WEST SUSSEX COUNTY COUNCIL CONSULTATION

TO:	Arun District Council FAO: Maria Tomalova
FROM:	WSSC - Highways Authority
DATE:	20 April 2020
LOCATION:	Babsham Business Centre, Babsham Lane, Bersted, PO21 5EL
SUBJECT:	BE/89/19/PL The change of use of land for the storage of building materials, equipment & plant & for the parking of 2no. articulated vehicles together with part boundary screen fence. Amended drawings received.
DATE OF SITE VISIT:	n/a
RECOMMENDATION:	More Information
S106 CONTRIBUTION TOTAL:	n/a

PROPOSED SITE PLAN - 1:200

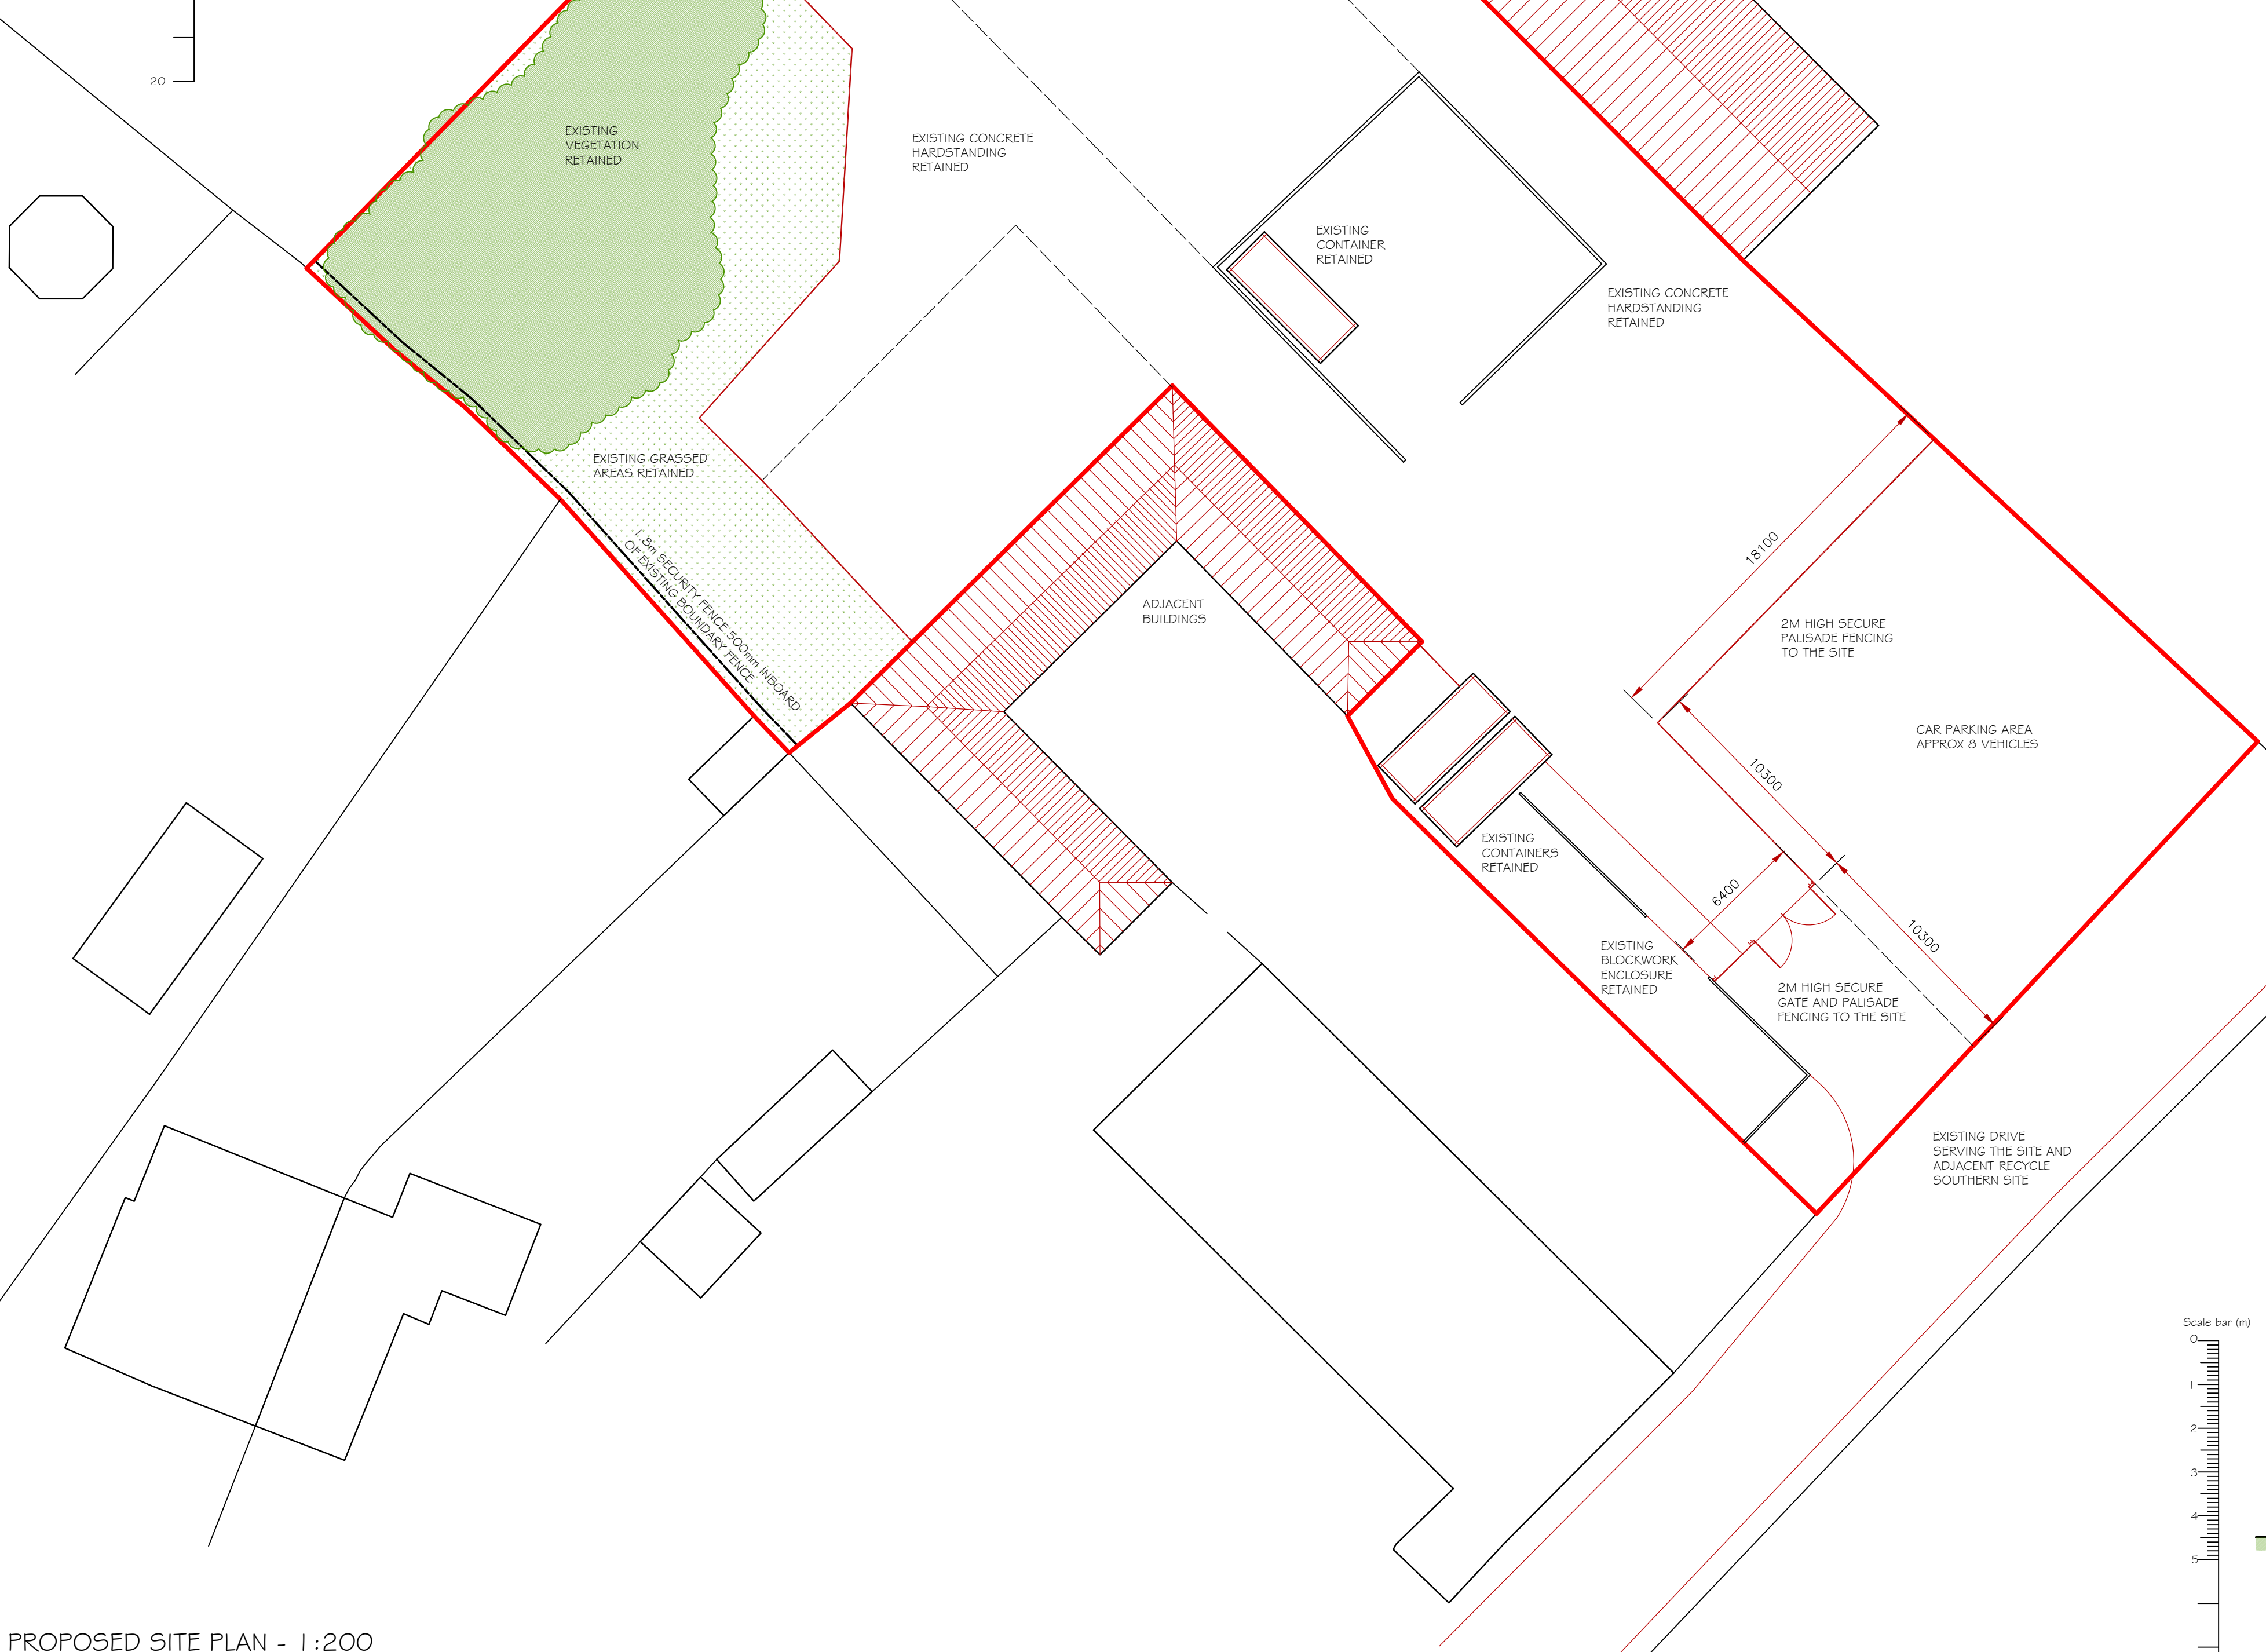
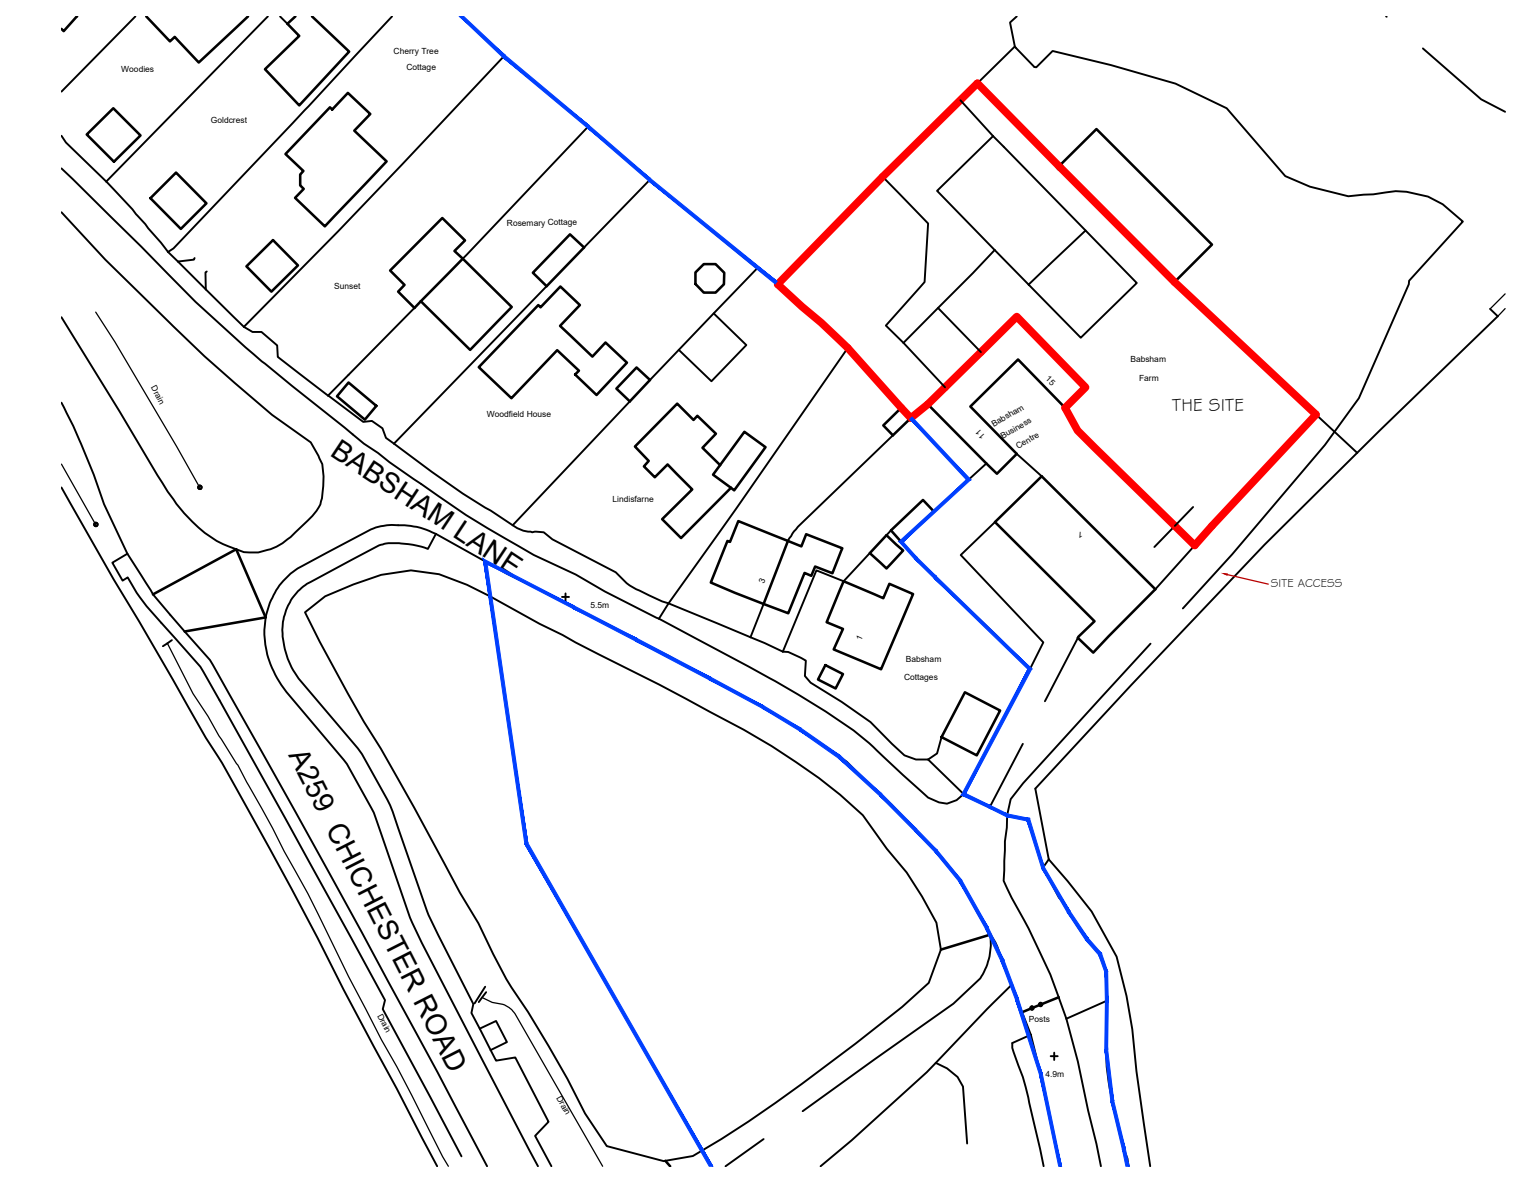
The revised plans remove the designated HGV parking area and demonstrate a car parking area for 8 vehicles. The LHA requests clarification as to location of the proposed parking area for HGVs. Is the applicant now proposing parking for up to 8 HGVs? The proposed plans should demonstrate where HGVs will be parked, and how these will be able to turn on site and exit in a forward gear, through use of swept path tracking.

The proposed gates are sited at a distance of 10.3m into the site. This is anticipated to be sufficient depth to enable vehicles to wait whilst the gates are operated without obstructing the access to the rest of the site.
